Your ref: SSD-93222706
Our ref: DOC26/244500

Subject: Environmental Impact Statement (EIS) - Waterloo Estate (South) Concept (SSD-93222706)

CPHR advice – EIS - Waterloo Estate (South) Concept (SSD-93222706)

Figure 1922: Stormwater

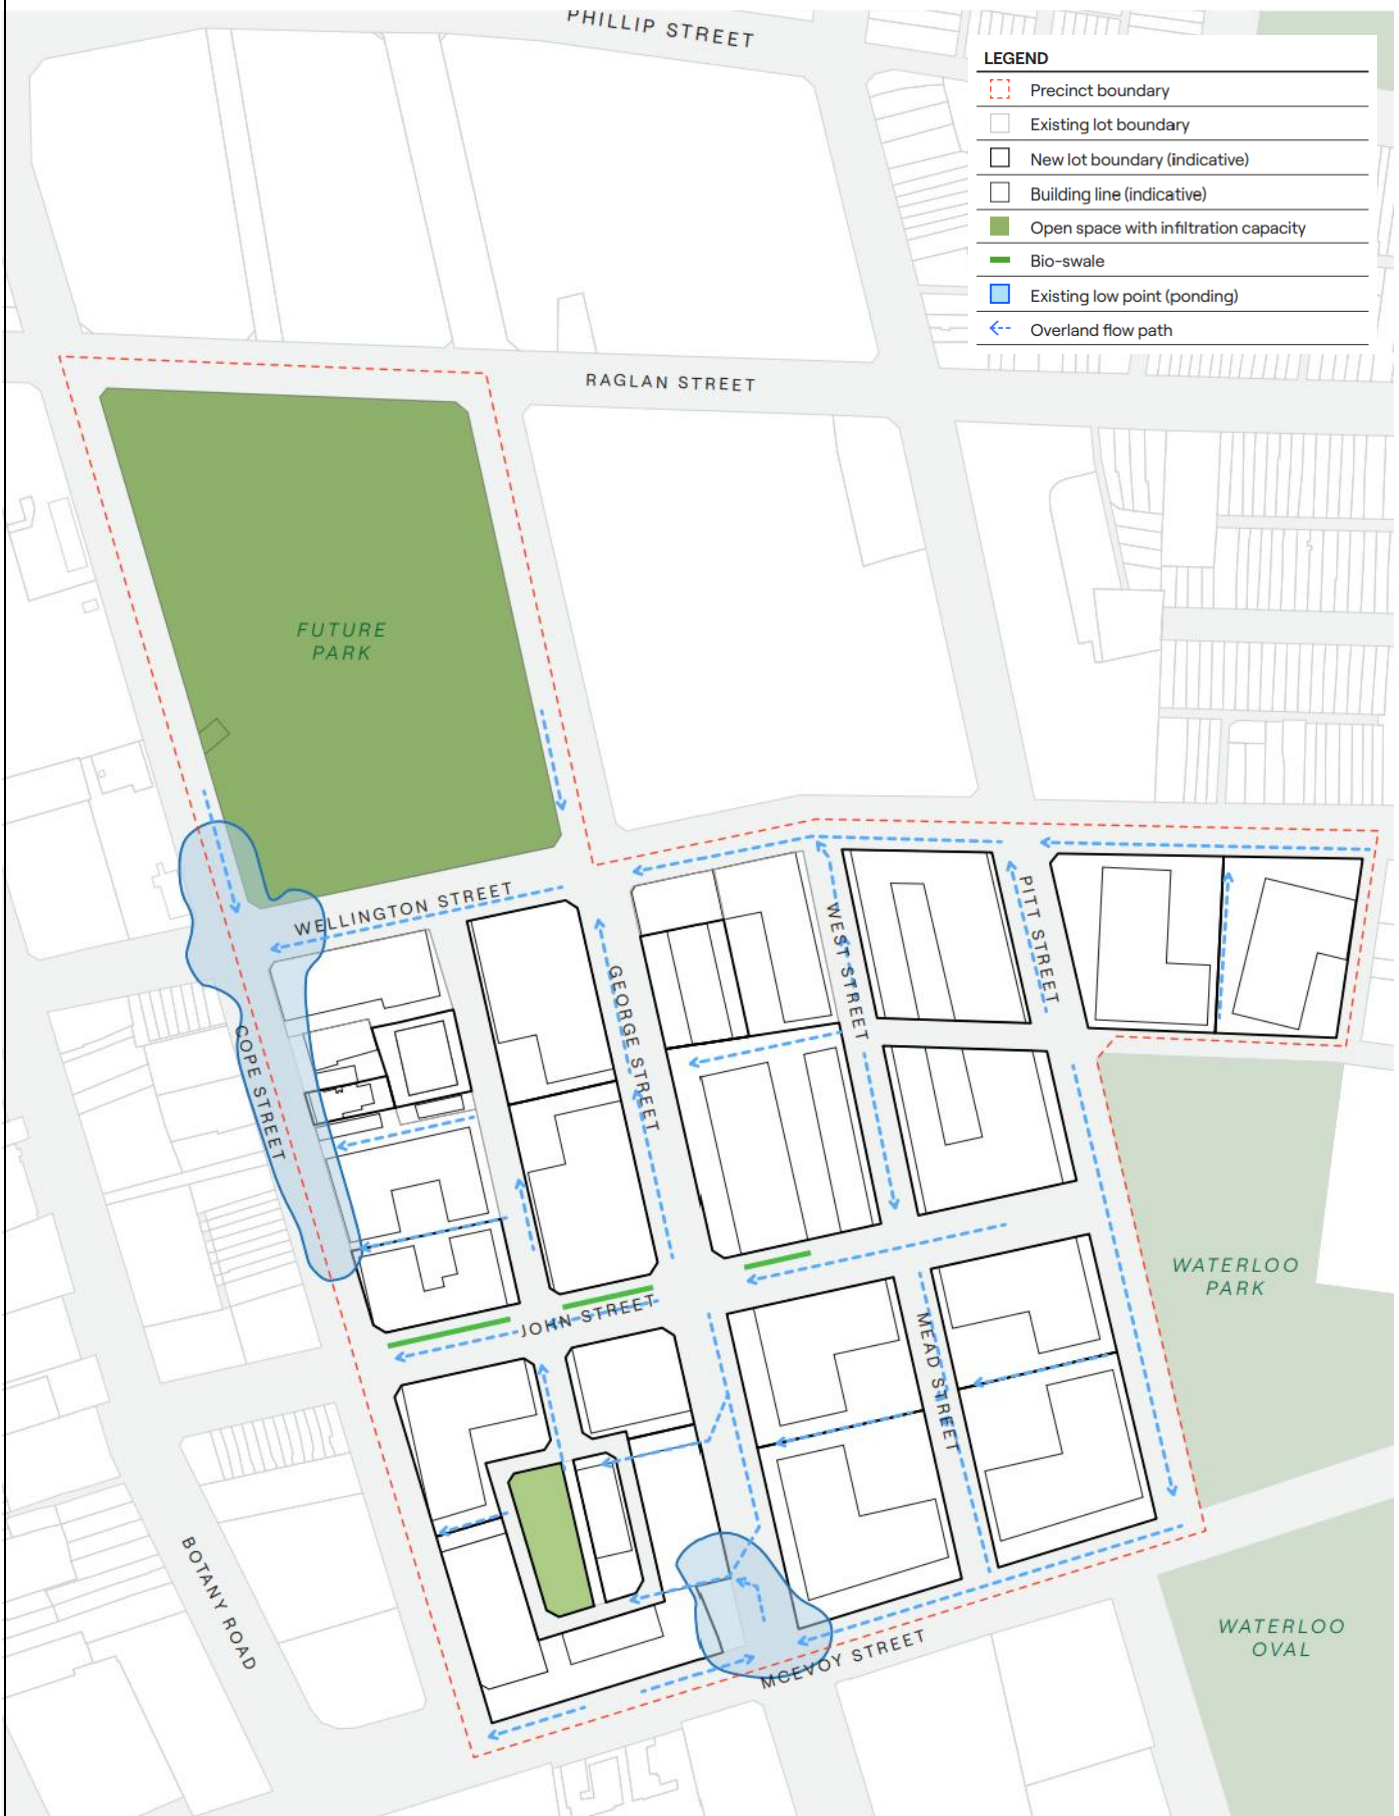
2	Impacts on local roadways are up to 100mm which would be considered unacceptable.	The FIRA indicates that flood impacts can be managed however it relies on existing landscape and roadway levels being maintained at the existing levels or potentially lowered to facilitate overland flow through the site. It is likely in detailed design that access issues will result in changes to these levels. The FIRA currently shows flood impacts up to 100mm in local roads serving the precinct due to restriction of flows to roadways around the enlarged building footprint. This is considered to be in excess of the generally accepted impact and will need further management throughout the progress of the development. Recommended action Update the FIRA as the development progresses. Mitigation measures will be required to reduce offsite impacts.
	<i>Extent and Timing</i>	During consideration of development applications or SSD applications for sites 8, 9, 2 and 3.

3.	The proposal is not yet developed to an extent where it is feasible to nominate finished floor levels to ensure protection of future buildings.	The FIRA nominates minimum finished floor levels to achieve Flood Planning Level Compliance including probable maximum flood (PMF) protection of the proposed basements. The levels nominated are likely to change through the detailed design and it has not been shown that the levels will be achievable and that this can be done with passive measures rather than mechanical protection. Recommended action Update the FIRA to ensure that finished floor levels and basement protection levels are achieved in the final design of each project. Passive protection of entry points to building and basement is required.
----	---	--

4.	Climate change impacts have been carried out as a sensitivity test only and have not been used to determine flood planning requirements.	The FIRA has carried out climate change sensitivity plans for the proposed development area and shows that the area is sensitive to climate change and that increase in flood levels occurs under the various climate change scenarios. Present day climate change levels in accordance with ARR4.2 would be the minimum design criteria. The developments are likely to be built over an extended period and have a long lifespan post construction. Floor levels and other mitigation measures should therefore achieve adequate protection to at least 2050 in accordance with the draft Climate Change and Natural Hazards State Environmental Planning Policy (SEPP) advice. Recommended action Use the climate change modelling results to enable design floor levels and other mitigation measures to achieve protection to at least 2050 in accordance with the draft Climate Change and Natural Hazards SEPP recommendations.

5.	Ingress of water into the buildings may result in inundation of basements.	The FIRA notes that shelter in place will be required for future development on site and that over floor flooding will occur for floods in excess of the modelled 1% Annual Exceedance Probability flood which requires access to floor levels above the PMF for each building. Over floor flooding will also compromise the ability to prevent water entry into basements. Recommended action Protect all potential entry points to the basement including lift shafts, fire stairs, ramps and ventilation openings to the PMF, particularly if shelter in place is the preferred evacuation strategy.
	<i>Extent and Timing</i>	During consideration of development applications or SSD applications.
